Planning Application No: **03/2012/1092**

Proposals: **Outline application for residential development of up to 140 units with primary access off Henthorn Road with all other matters reserved.**

Location: **Land off Henthorn Road**

Ecological comments

Title:
TREE CONSTRAINTS PLAN
in Relation to Proposal to Develop Site for Residential Usage

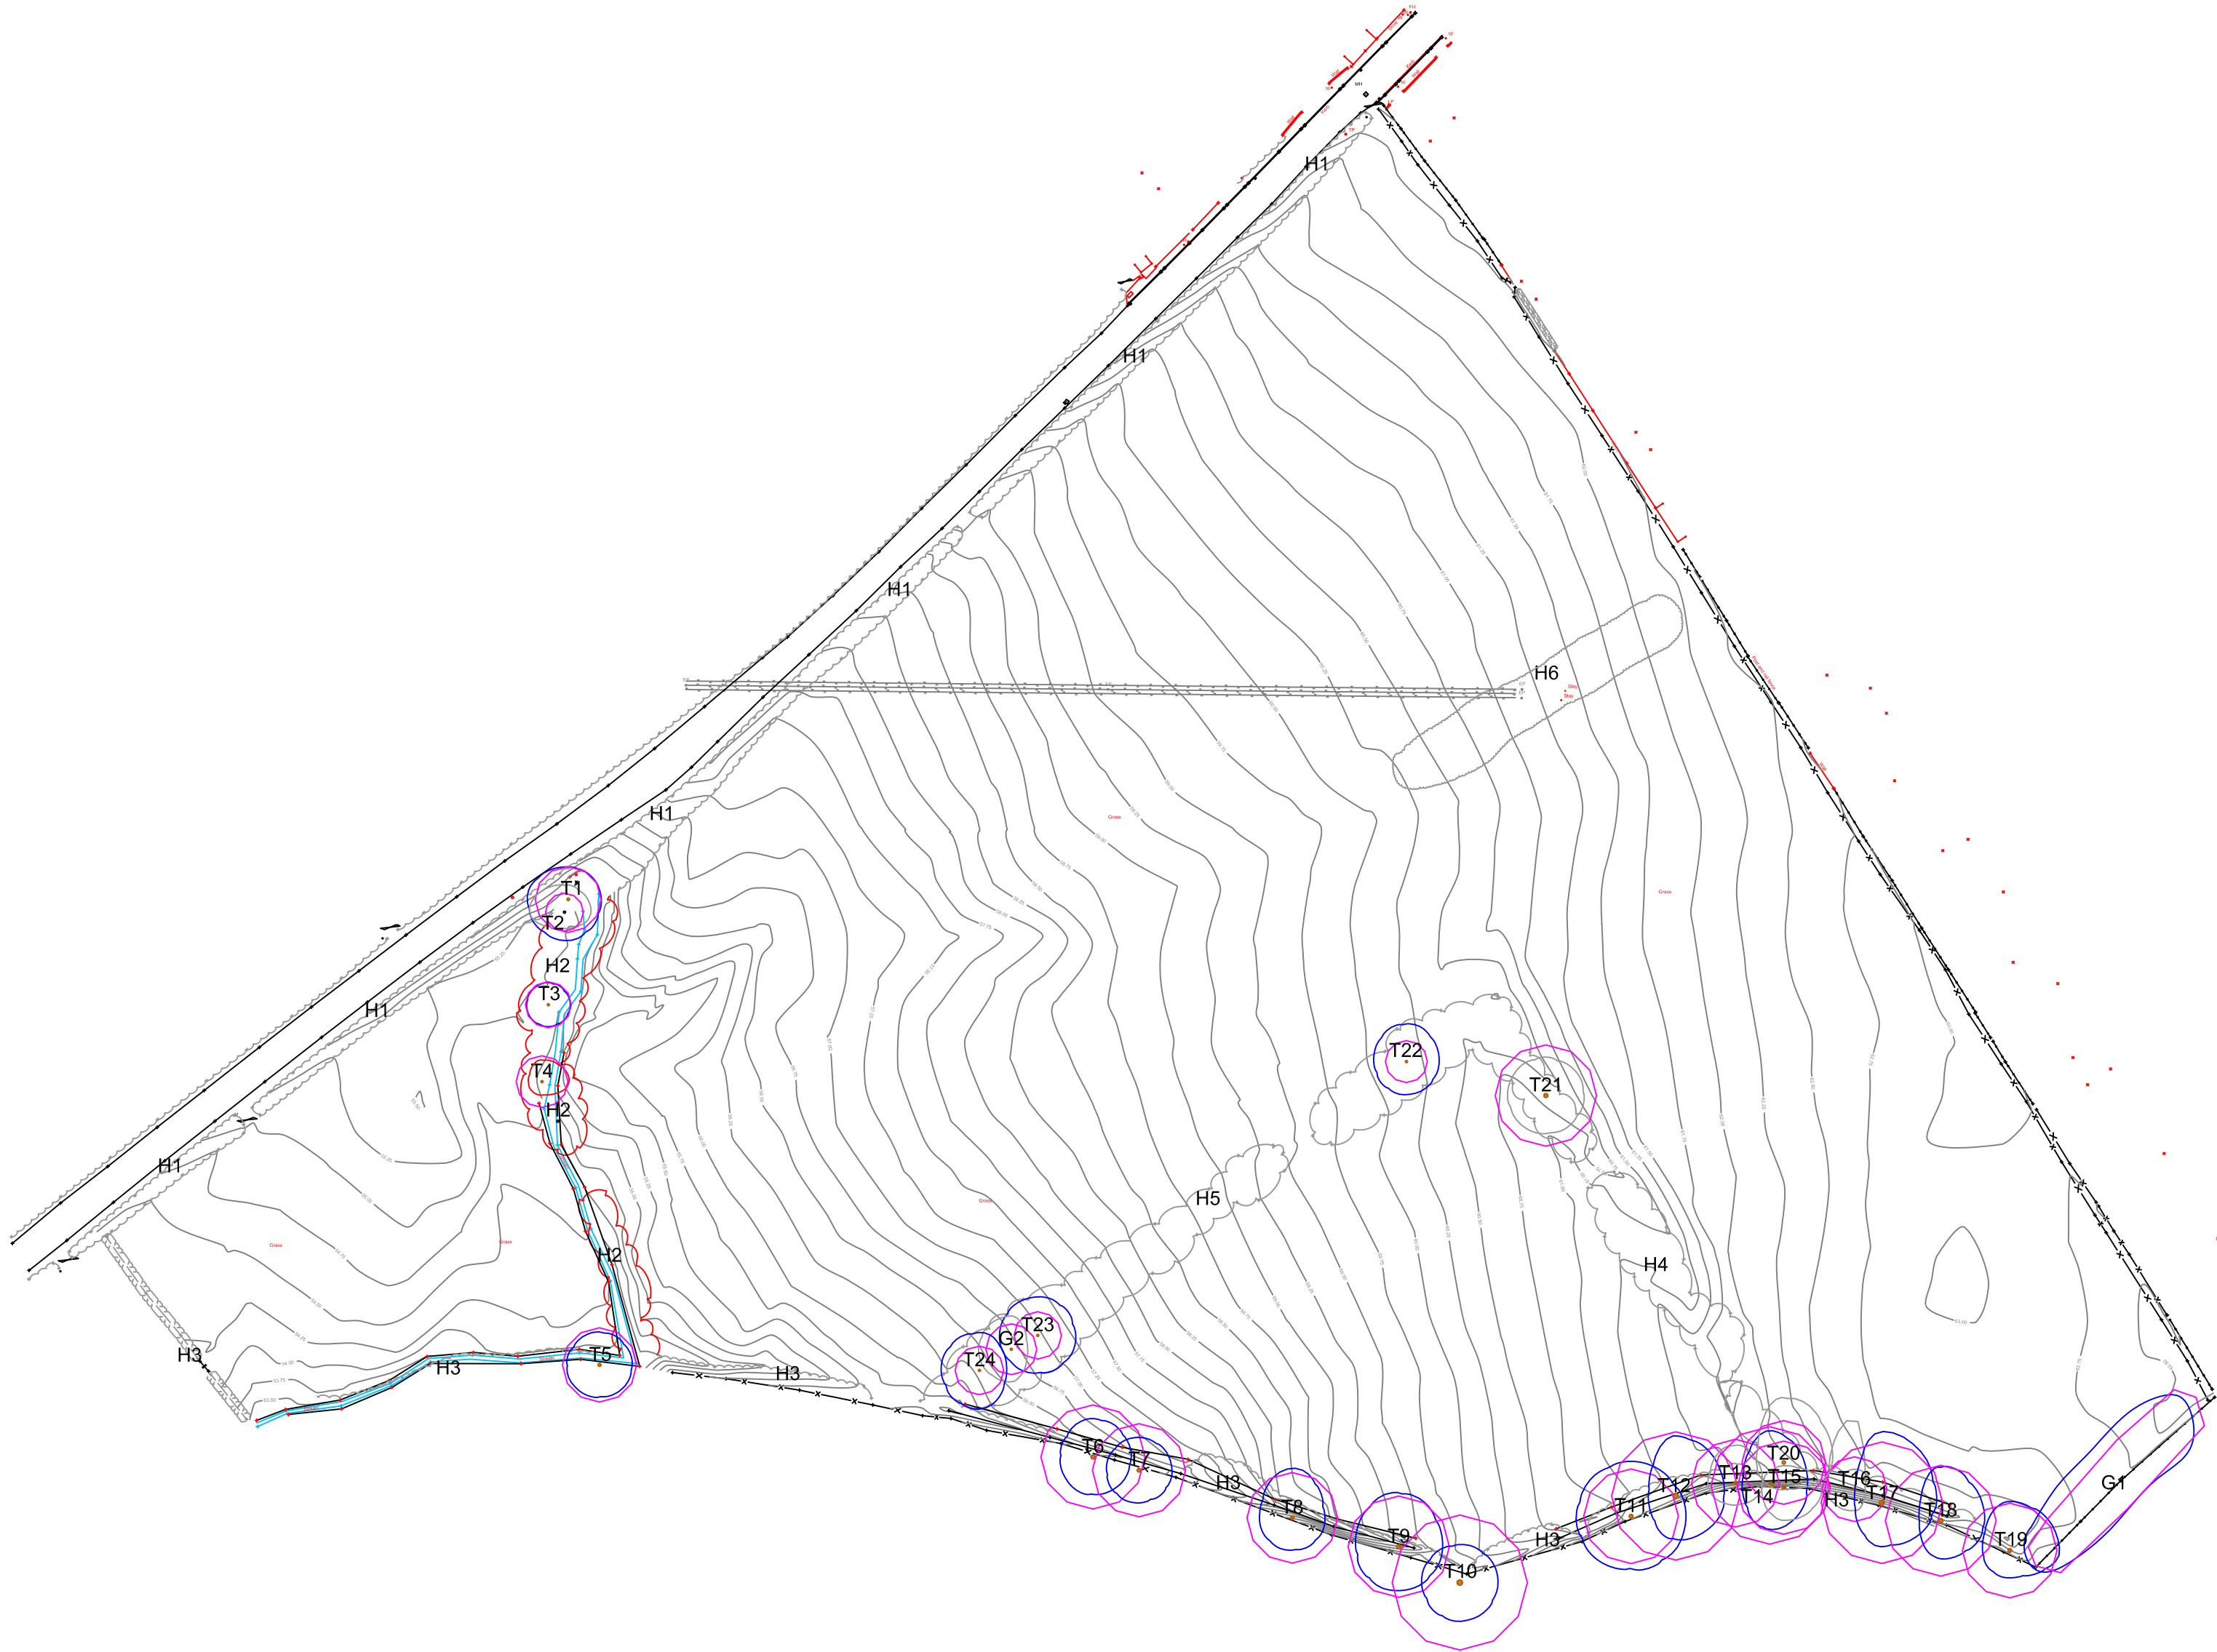
- The Illustrative Masterplan shows the removal of a number of trees and some of the trees within the hedgerows are suitable to support roosting bats. No information has been submitted regarding the likely impacts on roosting bats resulting from the loss of these trees. Unless a commitment can be made to retain all the trees, then further information will be required prior to determination of the application (see below).

- The Illustrative Masterplan shows loss of trees and hedgerows (a Habitat of Principal Importance). The RSS states that where proposals affect the region's natural environment, prospective developers and/or local authorities should first avoid loss or damage and the NPPF indicates that significant impacts should first be avoided (para 118). The Illustrative Masterplan does not appear to have addressed the avoidance of impacts. This should therefore be addressed at the reserved matters stage with the layout of any proposal designed around existing habitats. If impacts can be shown to be unavoidable then it will need to be demonstrated that there will be adequate compensation for any losses.

- Licences from Natural England may be required if protected species will be affected.
- The submitted tree report recommends works to trees including pruning and severing Ivy growth on trees. It is not clear whether these works form part of the proposed planning application or not. The applicant should be aware of the following:

- Ivy is a non-parasitic climber and is unlikely to cause direct harm to established trees. Ivy provides a valuable late nectar source for insects, habitat for nesting and wintering birds and provides roosting opportunities for bats. Therefore unless the Ivy is thought to be completely smothering out young trees (which does not appear to be the case on this site) it should be left in situ and intact.
